Re: Project 28 Pty Ltd v Minister for Planning (LEC 20161178476) – New South Wales Department of Planning response to without prejudice material

3. Proposed Underground Petrol Storage System

Our Reference 11728 ADV071216 NMS1D.docx

Groundwater Investigation - Borehole Location

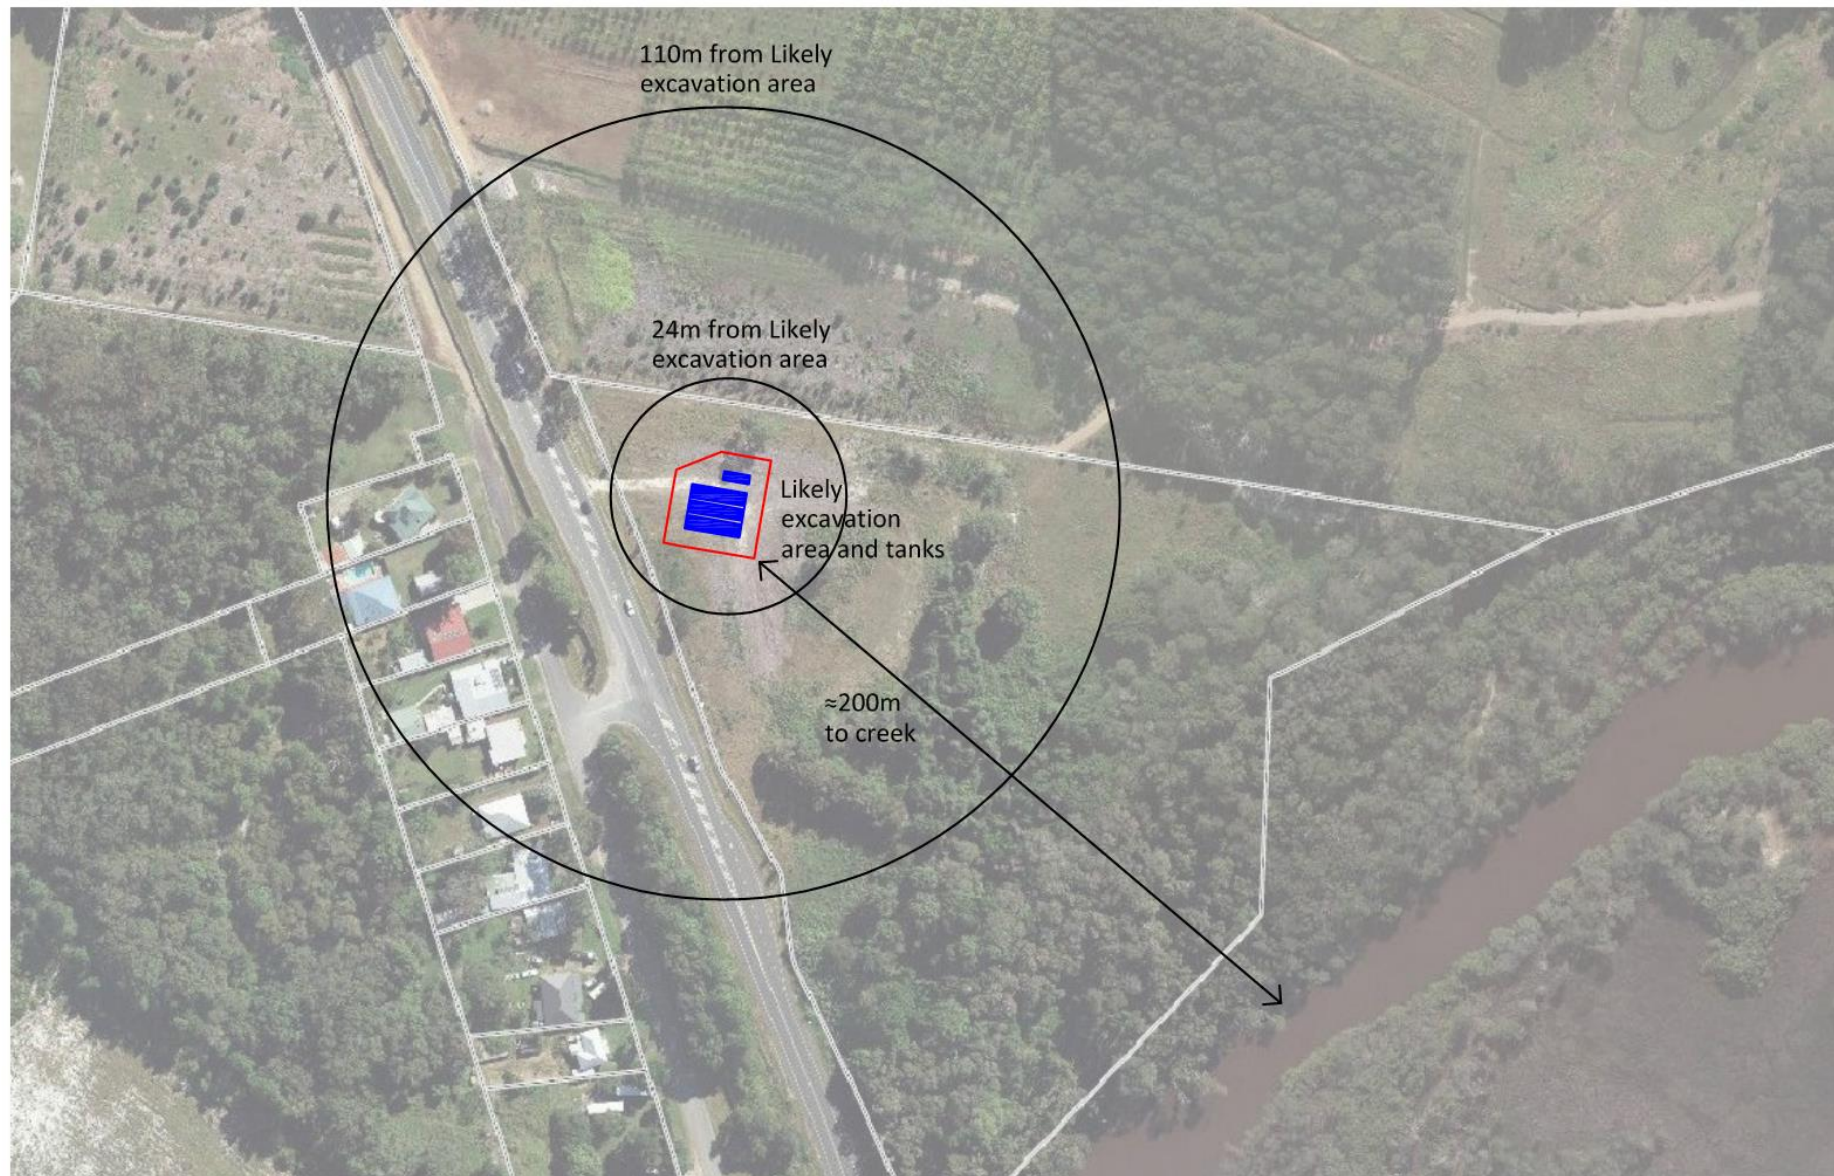
- *the use of both Automatic Tank Gauging and Statistical Inventory Reconciliation Analysis systems as the primary leak detection methods; and*
- *the use of both groundwater wells and interstitial monitoring as the secondary leak detection methods. The Department requires justification of the location of groundwater wells. This is usually identified within a Conceptual Site Model.*

Similarly Groundwater monitoring is an existing commitment of the SBMP (and a requirement of the *Protection of the Environment Operations (UPSS) Regulation 2014*). With regard to the location of the groundwater monitoring wells, site characterisation in the form of groundwater levels and flow direction modelling is ongoing, with data loggers installed. The loggers record the groundwater level every six minutes. It is proposed that the loggers remain in place until early in the new year. The data will then be downloaded and the existing conceptual model refined, based on the data. Suitable locations for the groundwater monitoring wells can then be identified.
